From: Adrian Dowd
Sent: 26 March 2021 13:00
To: Planning
Cc: Adam Birkett
Subject: FW: Consultation on planning application 3/2020/1037 Seed Hill (land to the rear of Grove Square, Chipping PR3 2GP)

The application is for proposed single storey building to be used as a holiday lodge and creation of new vehicular access off Malt Kiln Brow.

CLIENT: LIFESPACE CABINS				
PROJECT: SEED HILL CHIPPING PRESTON				
DRAWING TITLE: PRELIMINARY ACCESS PROPOSALS - SITE SECTIONS				
DATE CREATED: JULY 2020	DRAWING SCALE: 1-100	DRAWN BY: MWJ	CHECKED BY: -	QA CATEGORY: 1
DRAWING REF: TC / T19581 / 20 / 101				REV: A

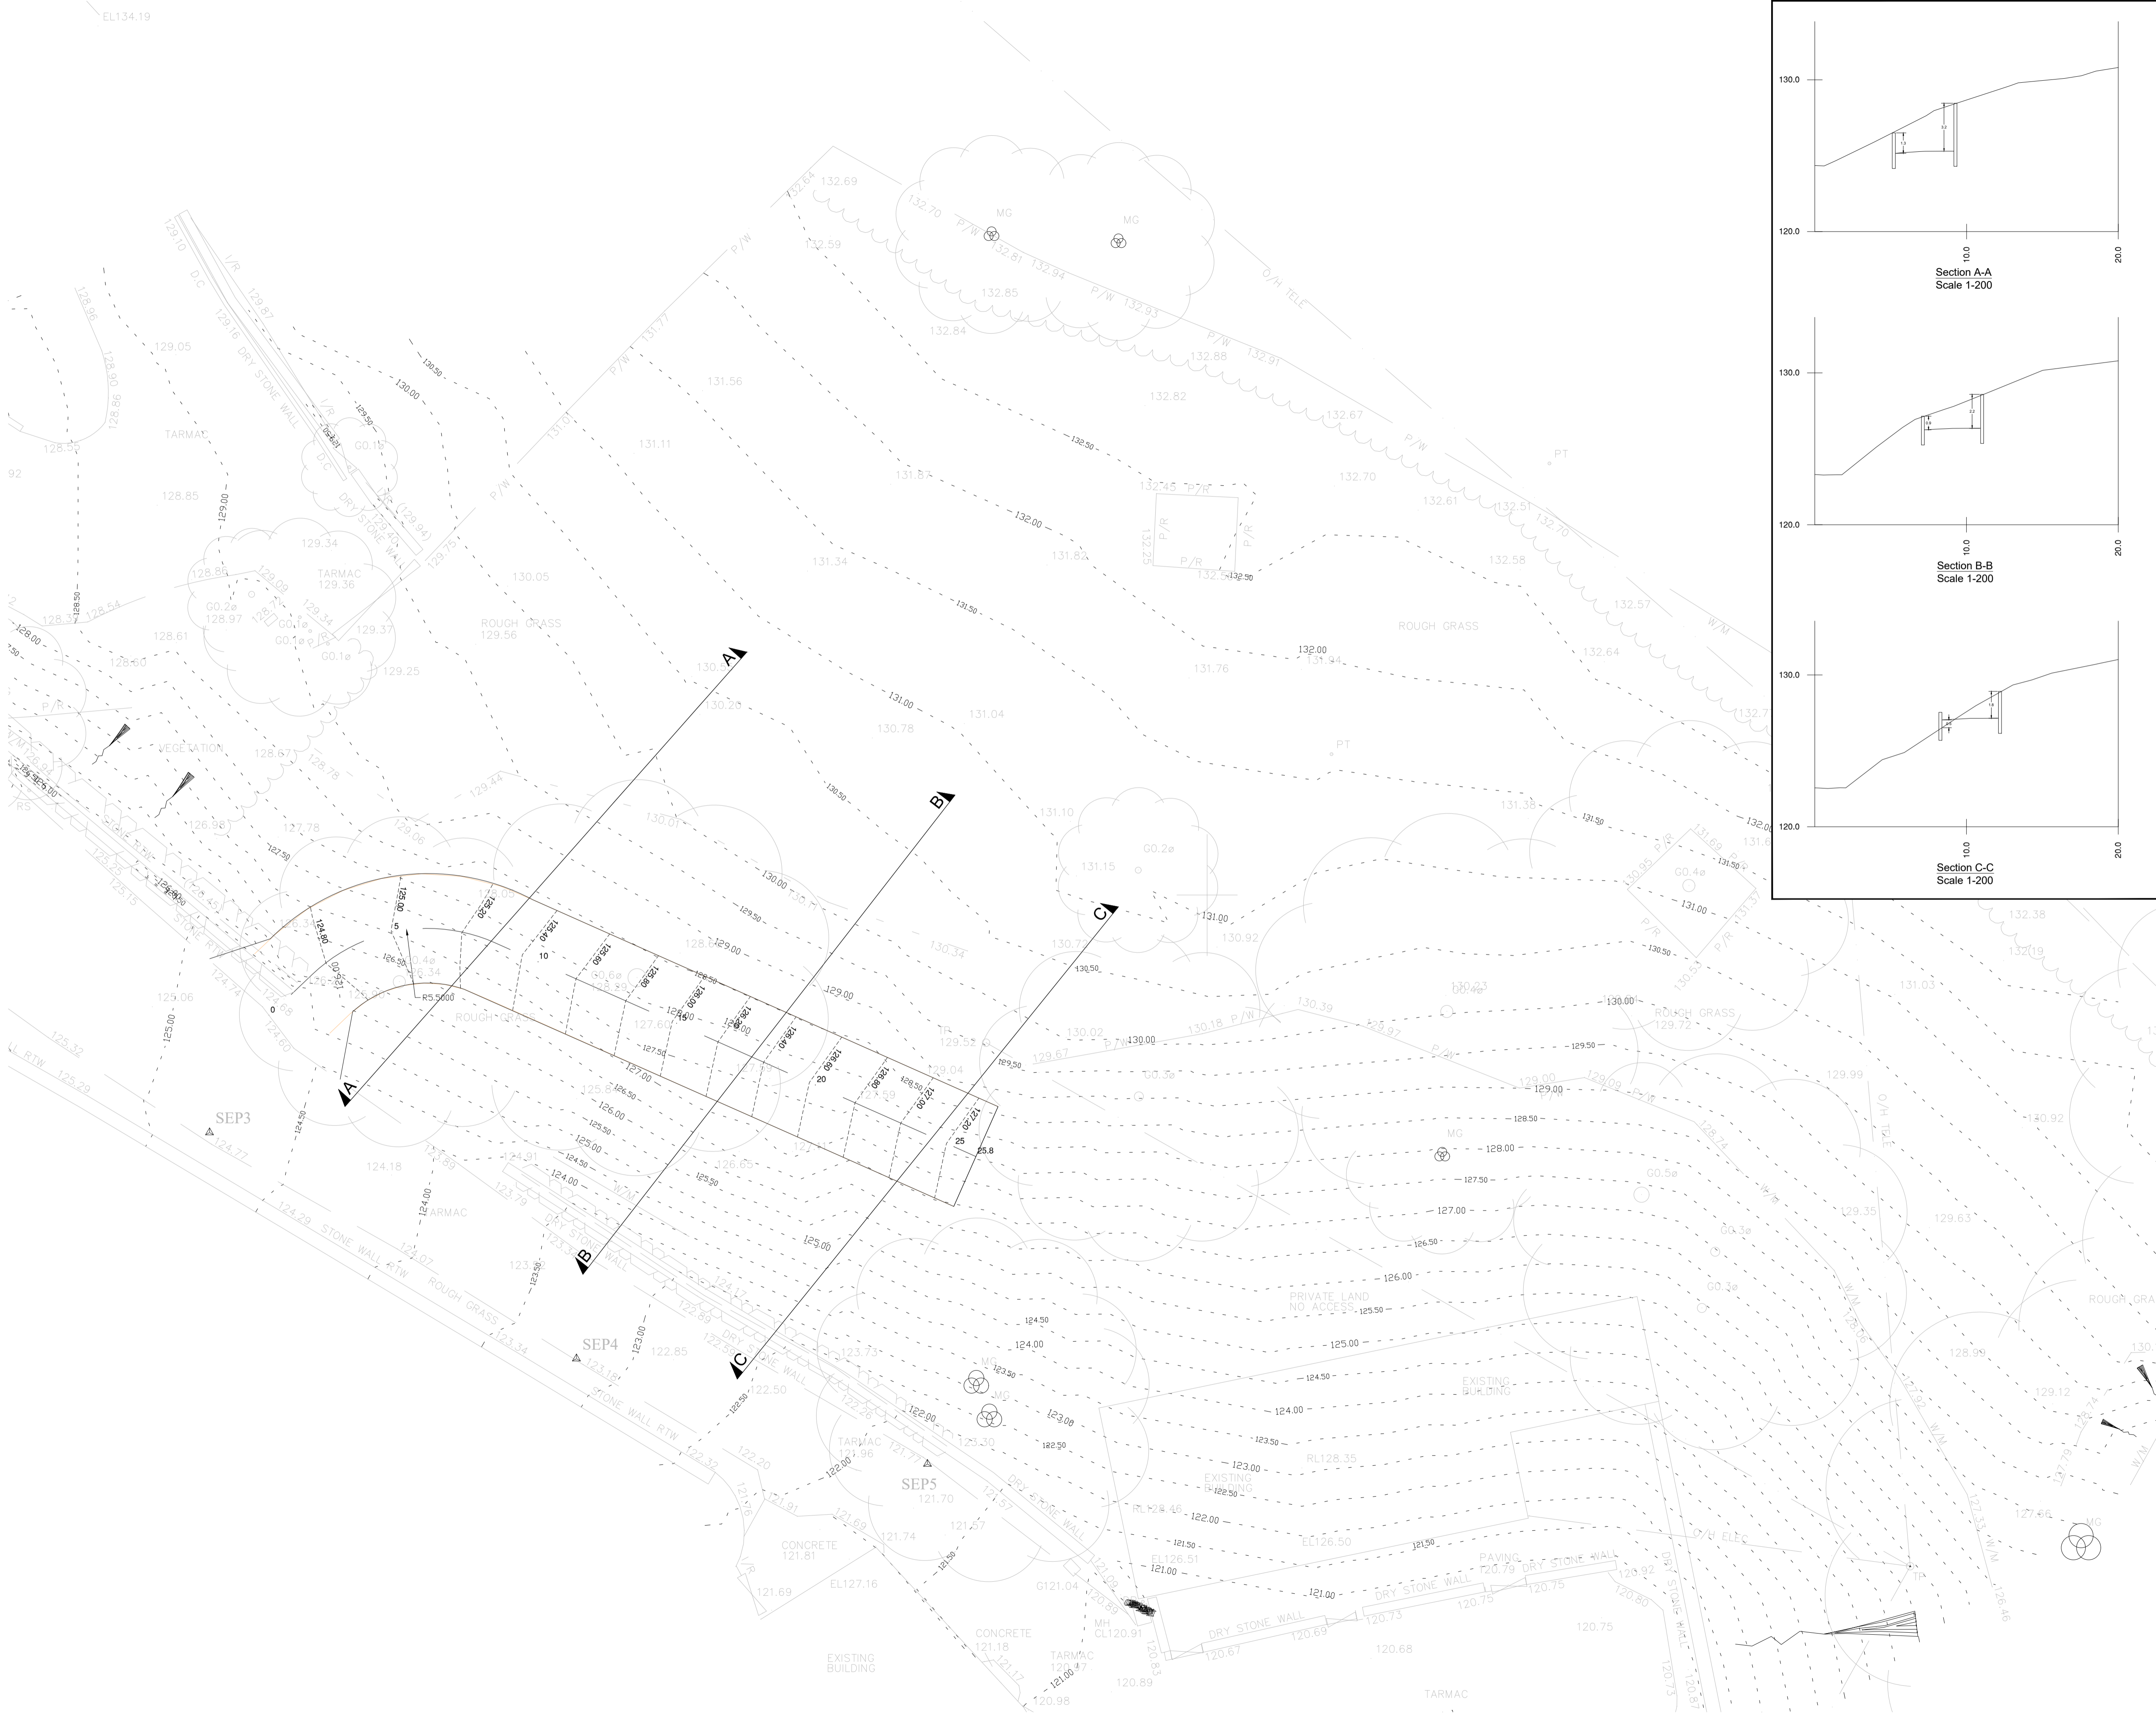
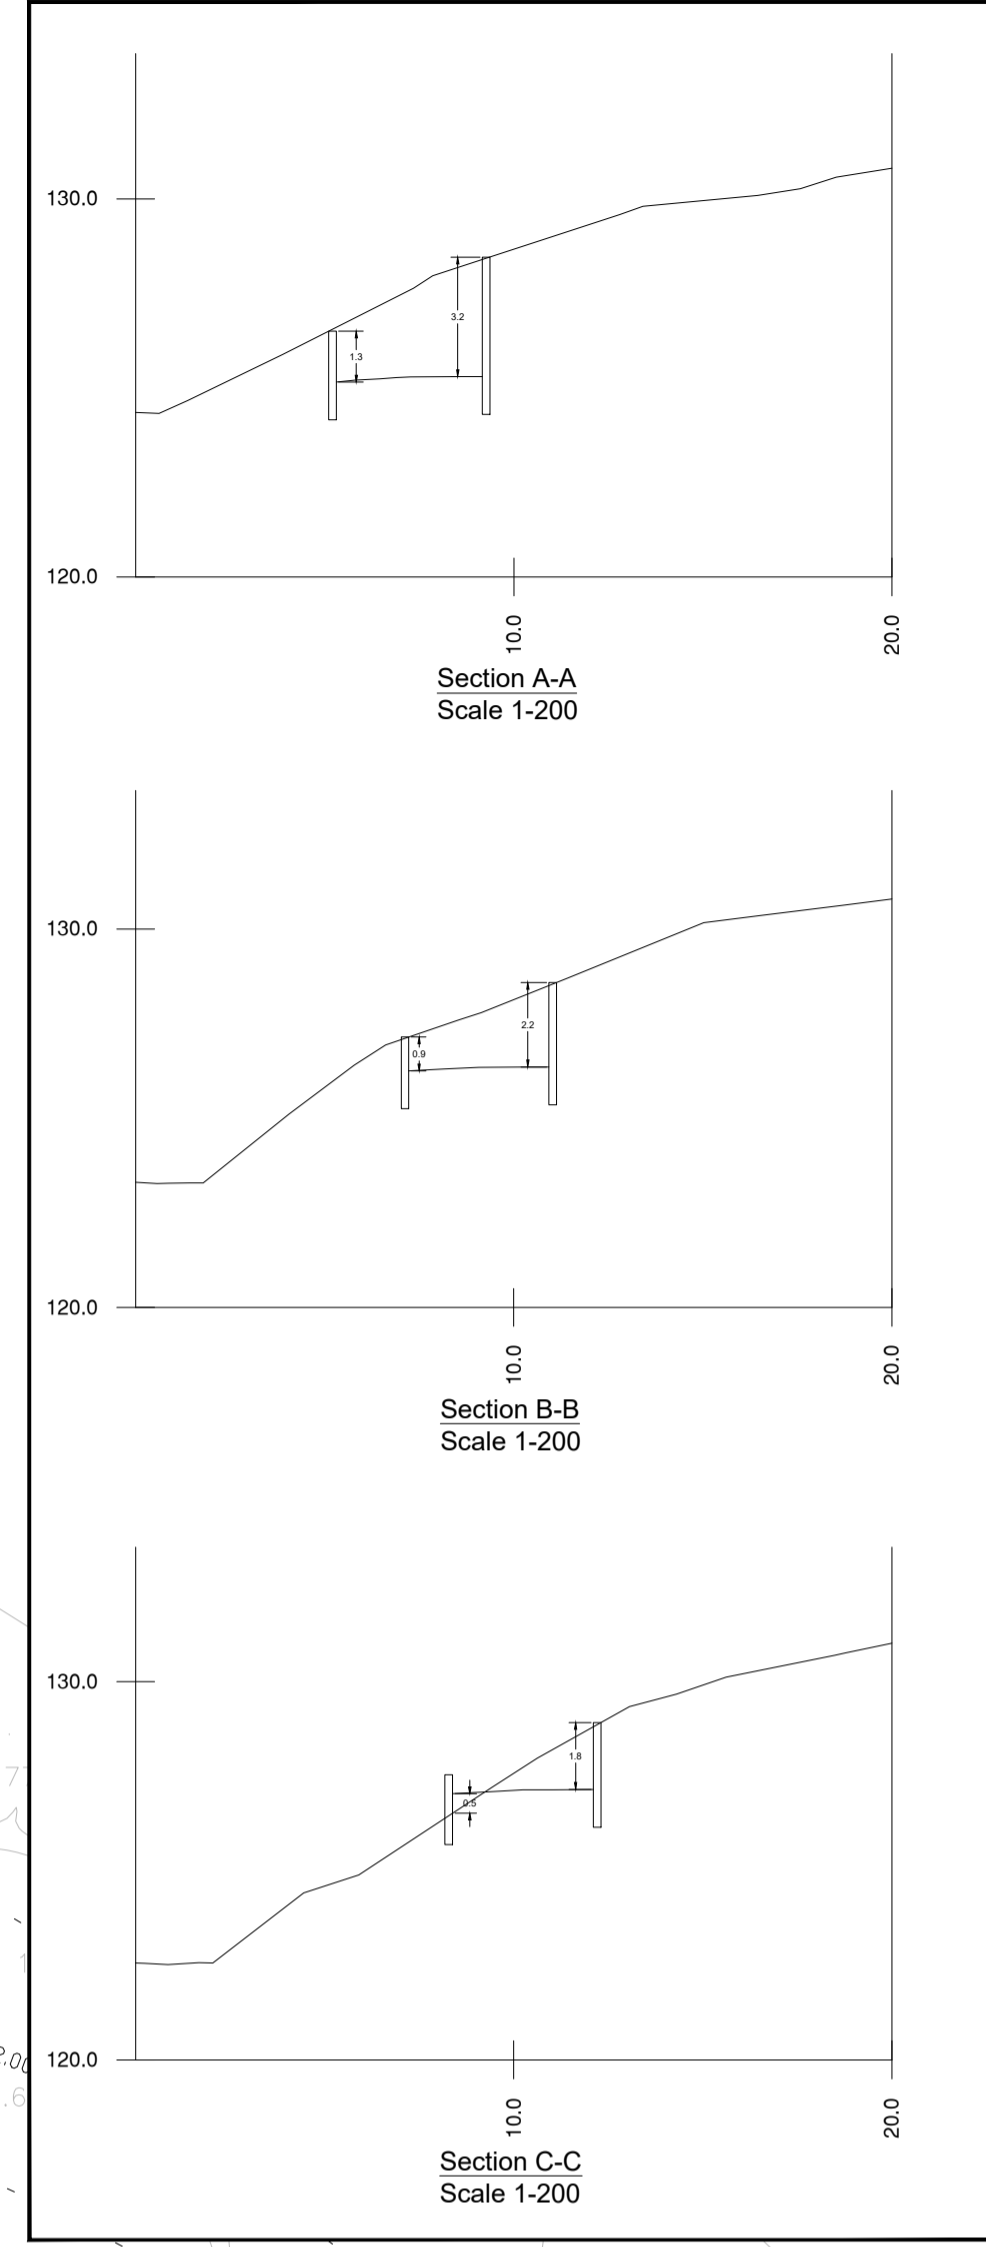
The proposed building will sit prominently on land above the mill complex and dominate and distract from the historic and architectural interest of the listed and other historic buildings (the SW elevation incorporates an expanse of reflective glazing). The engineered formation of a new access through the hillside opposite the mill pond is prominent, conspicuous and overtly modern. This land is part of the natural ‘bowl’ and is intrinsic to maintaining the isolated character of the mill complex (including separation of the modern Mill Pond House from historic buildings).
